WEST SUSSEX COUNTY COUNCIL CONSULTATION

TO:	Arun District Council FAO: Mr D Easton
FROM:	WSCC – Lead Local Flood Authority
DATE:	30 th May 2022
LOCATION:	Barnham, Eastergate, Westergate BEW Parcel SC1 Barnham
SUBJECT:	BN/11/22/OUT Outline application with all matters reserved (except for the A29 Realignment) for the demolition of existing structures and mixed use development to provide up to 1,250 residential dwellings (Use Class C3), Care Home/Senior Living Accommodation (Use Class C2/C3), flexible retail and community floorspace (Use Classes E/F2/Sui Generis), a Primary School plus open space, landscaping, drainage and all other associated ancillary works; and realignment of the A29 and early connection to existing A29 including construction of a new road carriageway, junctions and associated infrastructure. This application also lies within the parish of Aldingbourne, affects the setting of listed buildings, affects the character & appearance of the Eastergate Church Lane Conservation Area and affects a Public Right of Way. This application is the subject of an Environmental Statemen

Figure 12.1 Watercourse location plan

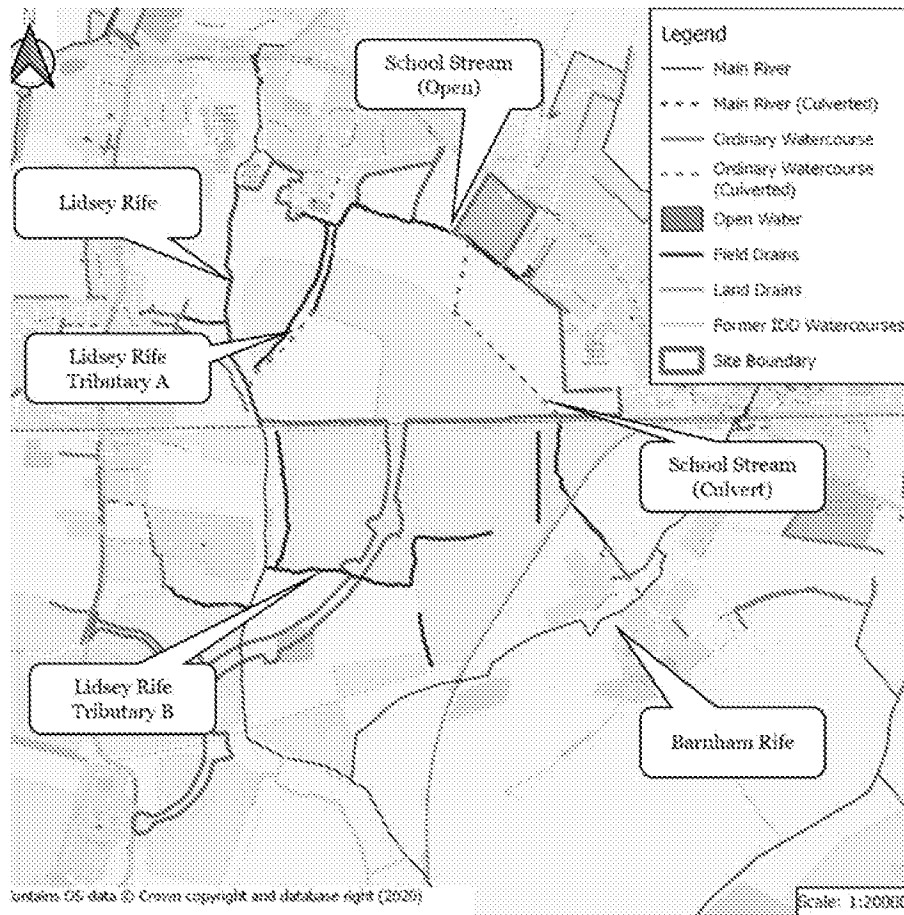
Ordinary Watercourses nearby?	Yes
Comments: Current Ordnance Survey mapping shows ordinary watercourses running across the site. Local or field boundary ditches, not shown on Ordnance Survey mapping, may exist around or across the site. If present these should be maintained and highlighted on future plans. Works affecting the flow of an ordinary watercourse will require ordinary watercourse consent and an appropriate development-free buffer zone should be incorporated into the design of the development.
